R/215/25/HH
PL- rep- please redact

Scales: **1:100** No: **3434/01/02**

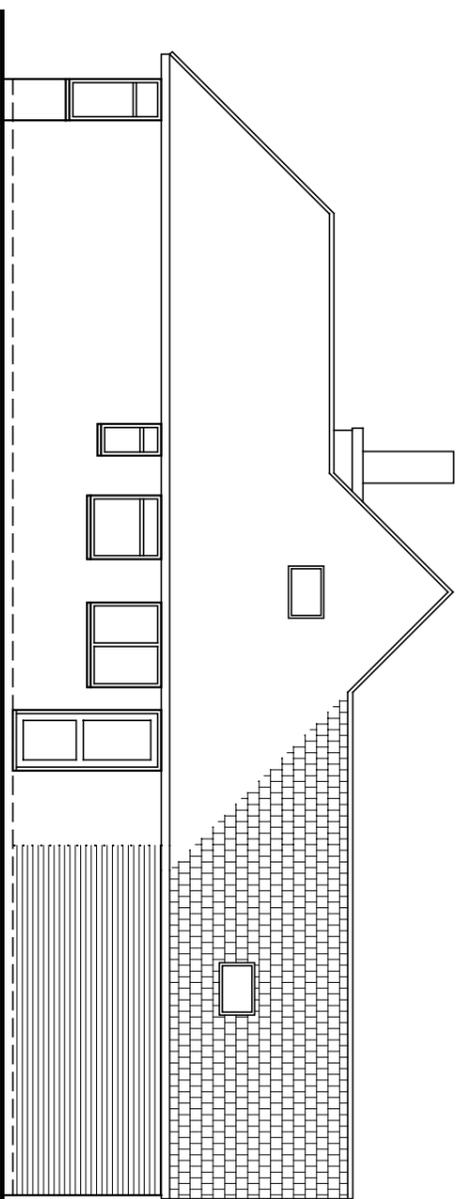
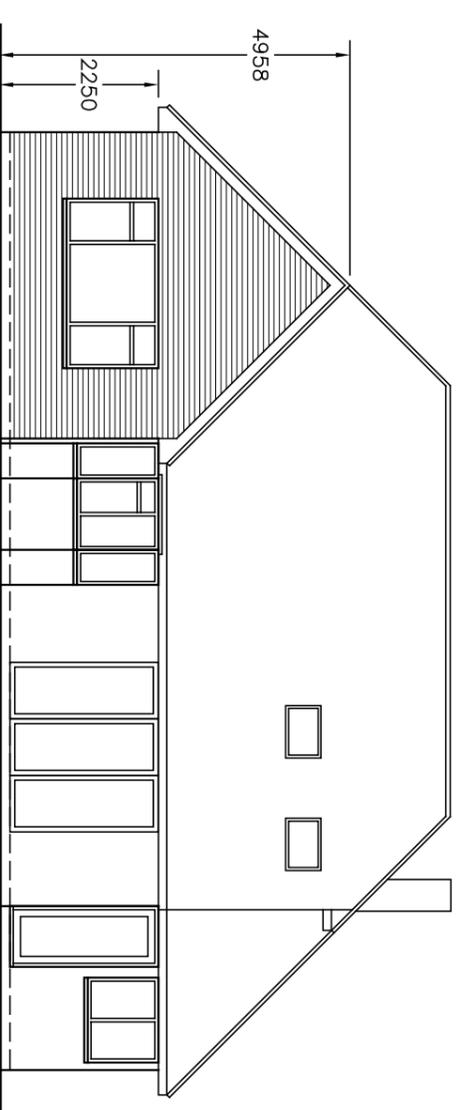
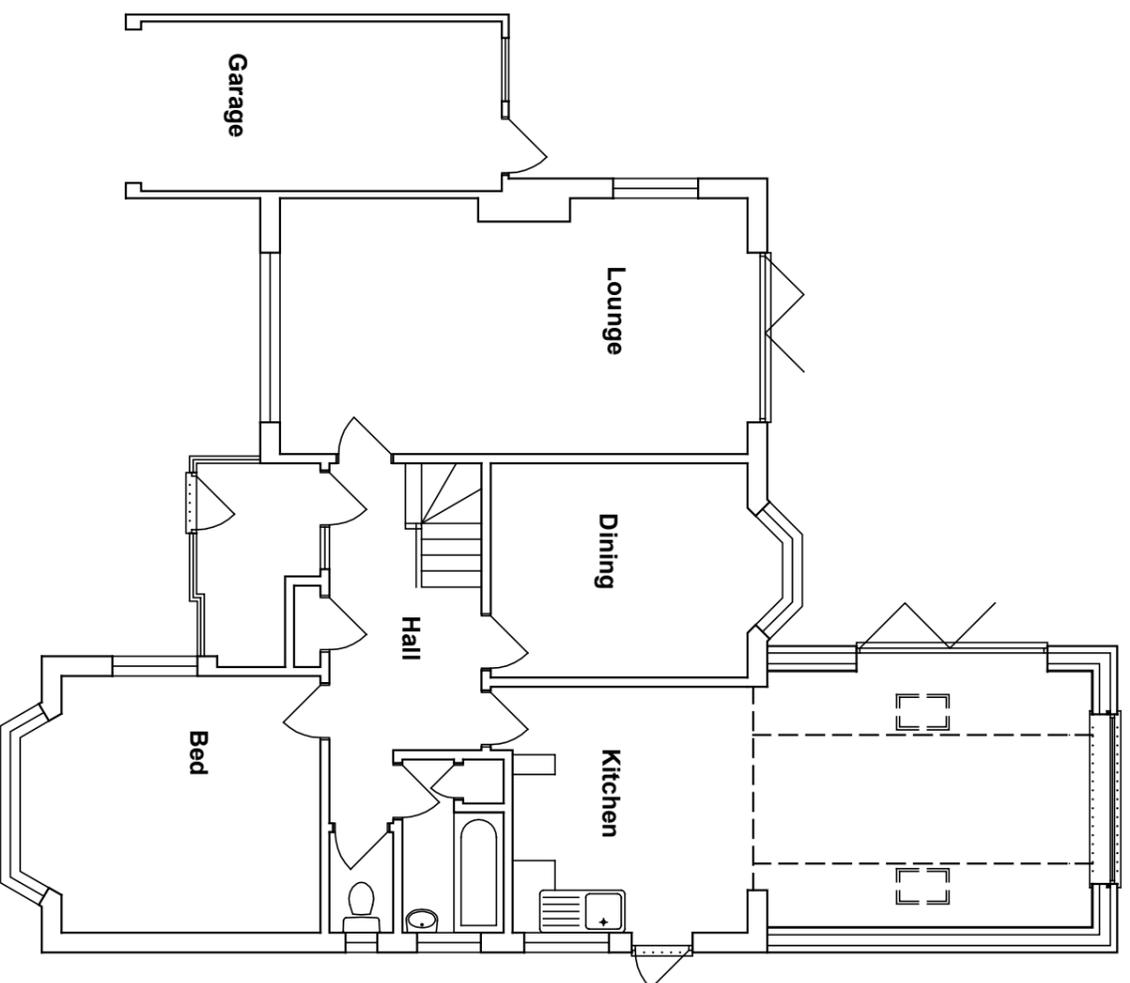
Proposed plans will leave "21 ft of brick wall and gutter " , running along my south border view,

my south border outlook would be unsightly over shadowing overbearing ,intrusive unsightly

my south border where light comes from is where thompsons plan to build ,wall and gutter will be high enough to make this occur
